**Please find below our requirements for agreement in second discharge of conditions.**

Development: Variation of condition 8 (first & second floor northern elevation windows) and condition 10 (approved plans) on planning permission 6/2016/1857/VAR At Location: Flats 15A-E, 15 Station Road, Cuffley, EN6 4HT

Application Date: 29 March 2019

Approved Date: 11/June/2019

bin stores as built

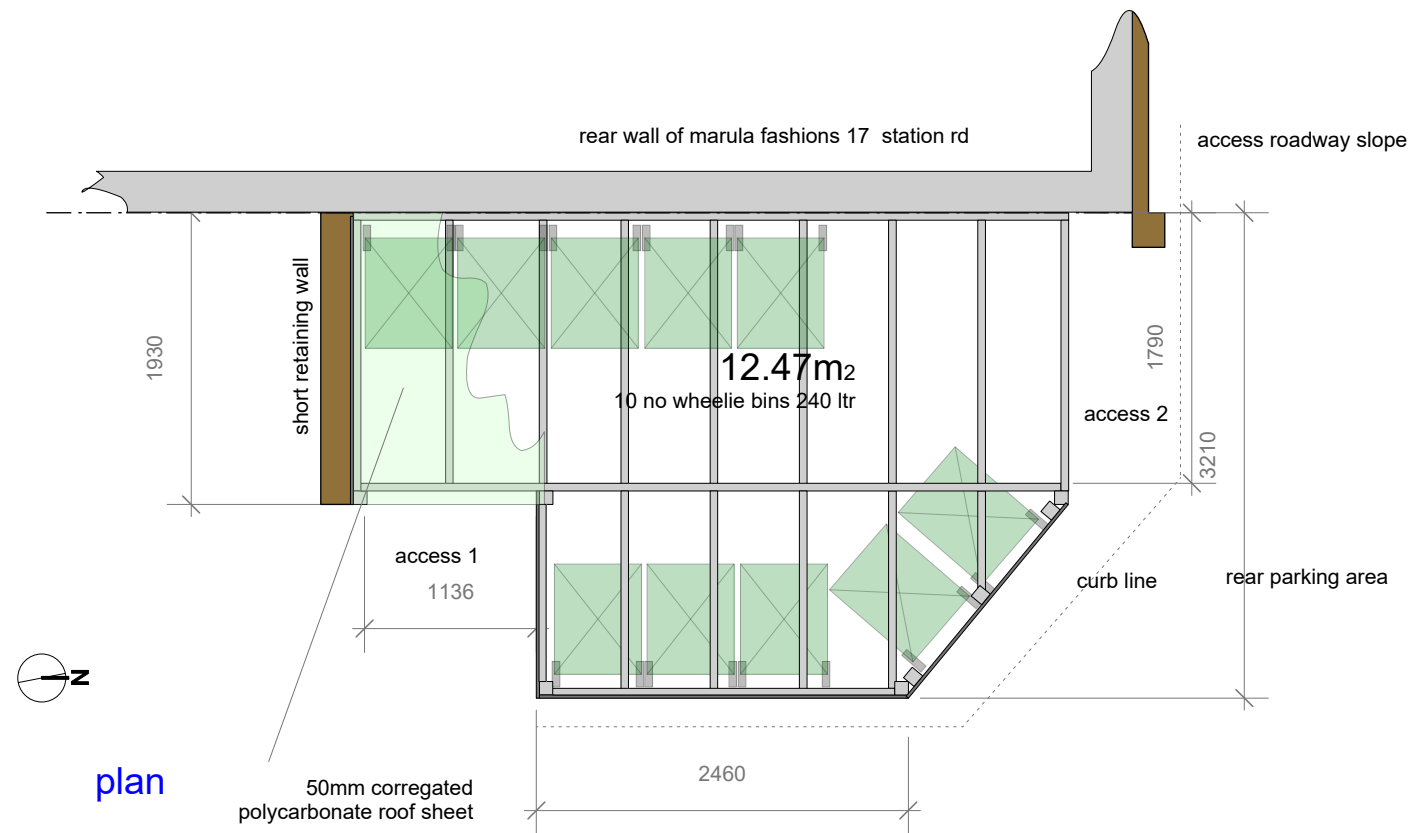
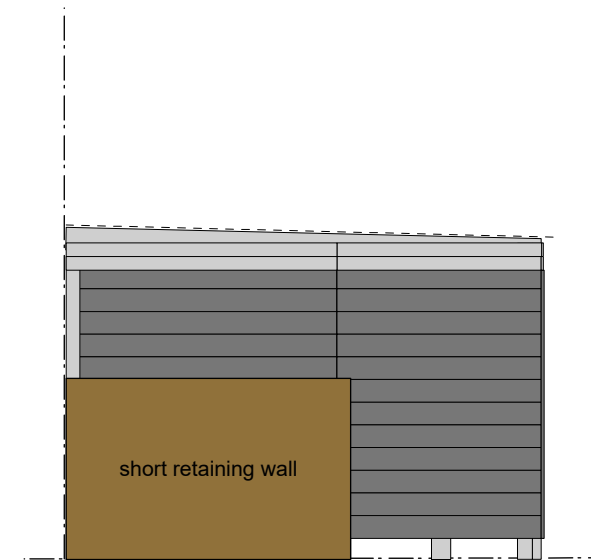
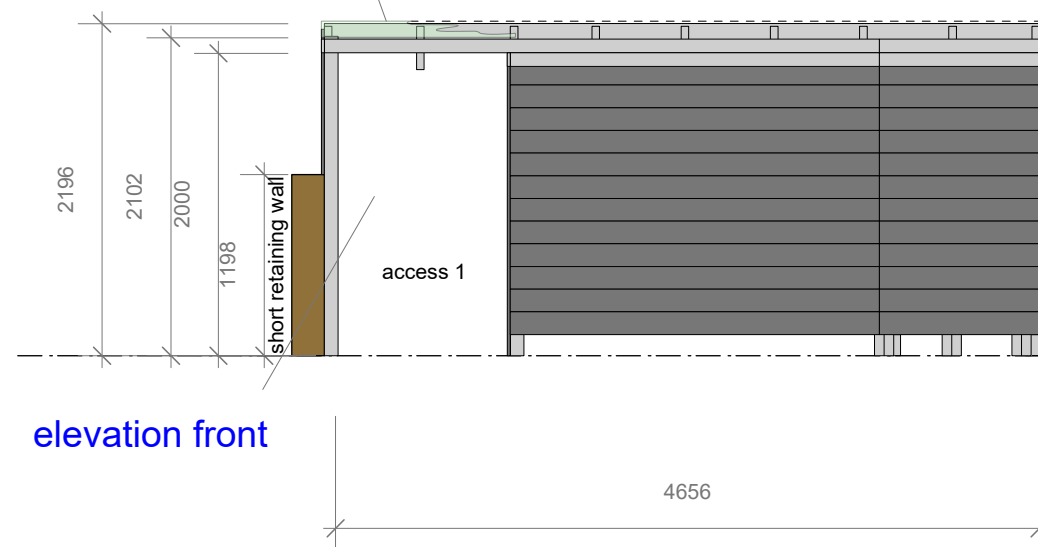
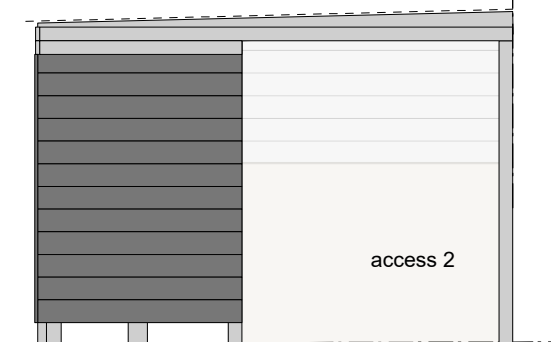
We have had to move our previously agreed internal Bin Stores Area from the building to a dedicated external bin store in the parking area.

Please see details and images on the attached drawing provided – for agreement/synchronisation.

- Residents and Shop tenants complained of the smell of the bins in close proximity to their habitable areas.
- Building control insisted on blocking access to the internal bin store from the foyer making manoeuvring rubbish bags into wheelie bin awkward also for collection.
- The space was not big enough to accommodate the sheer number of wheelie bins required including recycling bins.
- Access was impossible as direct door access in my original design was deleted under guidance from Regional Building Control.
